TfNSW reference: WST24/00213/002, WST22/00202, SF2024/103126

SSD-50505215 – EIS Exhibition Bullawah Wind Farm - Request for additional information

Transport for NSW (TfNSW) is responding to the exhibition of the Environmental Impact Statement (EIS) for Bullawah Wind Farm referred via the Major Projects Portal on 21 August 2024. TfNSW have reviewed the EIS and the Traffic Impact Assessment (TIA) (Appendix 2) as key reports in formulating this response.

Figure 13 Wagga Wagga – Roundabout at the corner of Mason Street / Norton Street and Hammond Avenue (Sturt Highway)

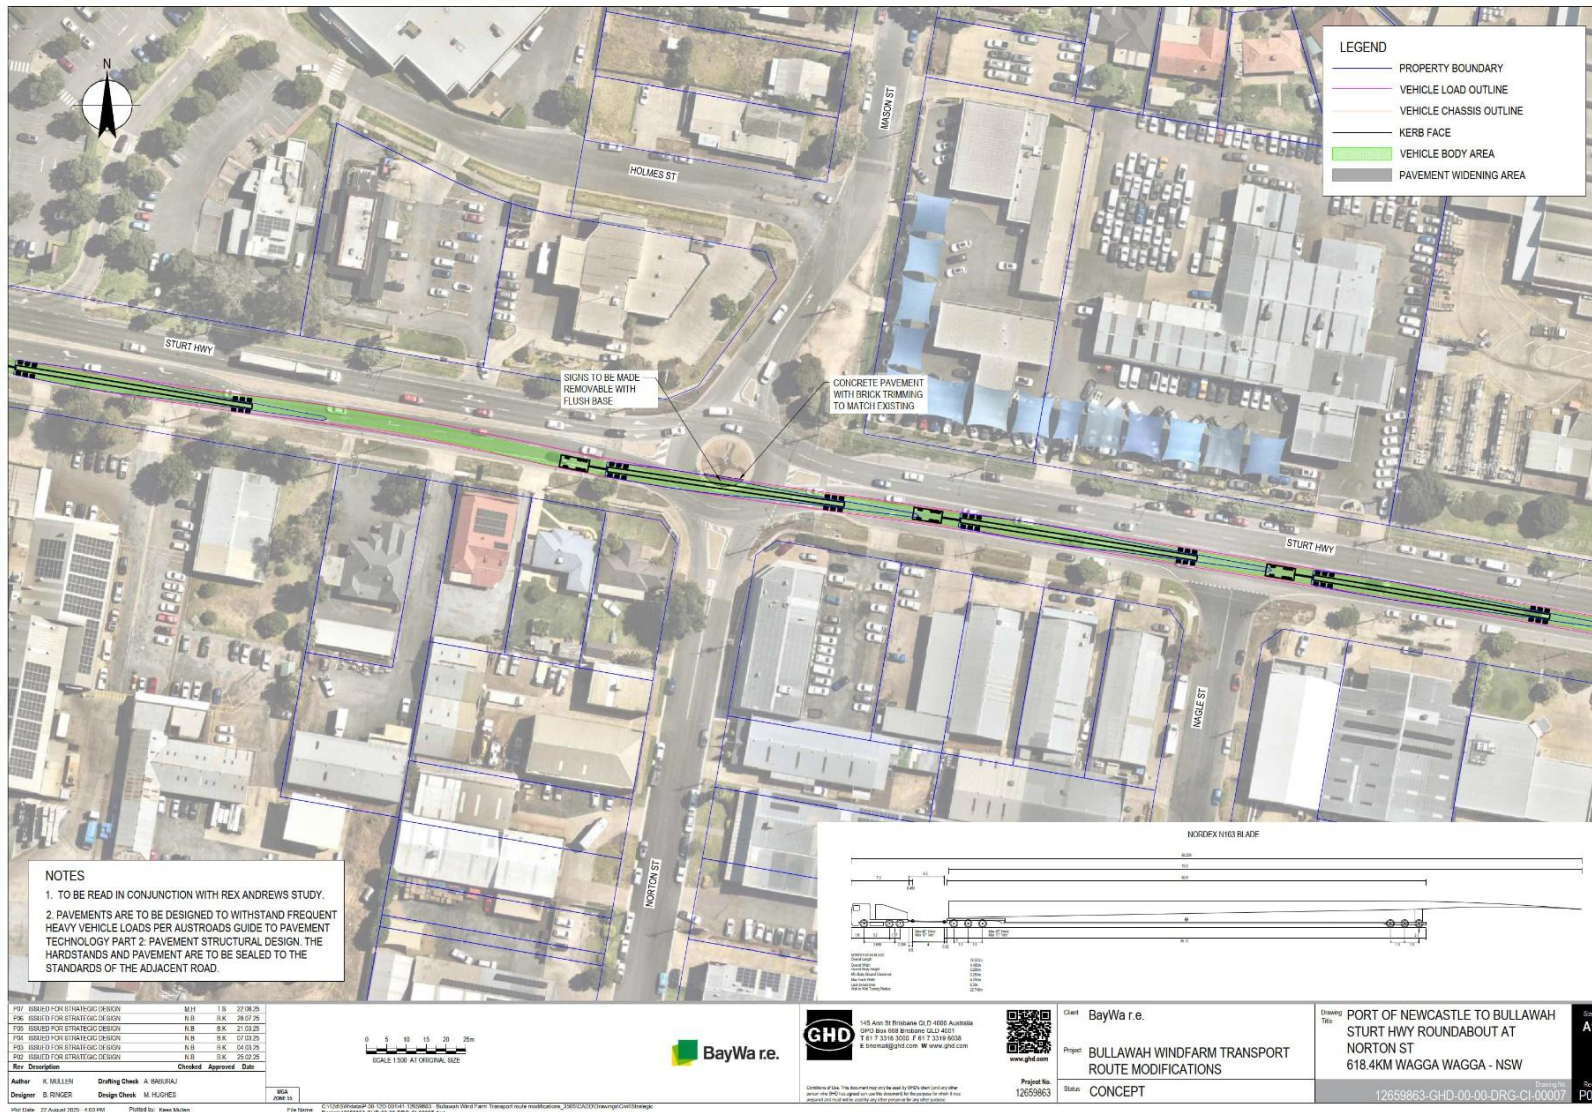
- f. Provide within the updated route assessment further assessment of roundabout intersections identified on the Sturt Highway through Wagga Wagga addressing the following:

- Clarification on whether a portion of roundabouts will be removed or if it is proposed to mount existing annulus(s). If mounting is required, assessment of the existing suitability or upgrades required to the roundabouts for the movements must be included.

- Swept paths and road design plans are needed to confirm the impacts on the roundabout(s).
 - Vegetation trimmed or removed and other infrastructure to be removed or modified.
- g. The removal of traffic islands at the Gillenbah Road/Sturt Highway pinch point to facilitate the high-risk OSOM movements will conflict with the service centre conditions and infrastructure to prohibit right turns into Gillenbah Road. Designs to navigate this pinch point without impacting service centre consent conditions must be investigated and included within a revised route assessment.
- h. The Cobb Highway/ Jerilderie Road widening must consider longitudinal drainage on the Cobb Highway. A pipe may be required under the hardstand area. Strategic designs are required.
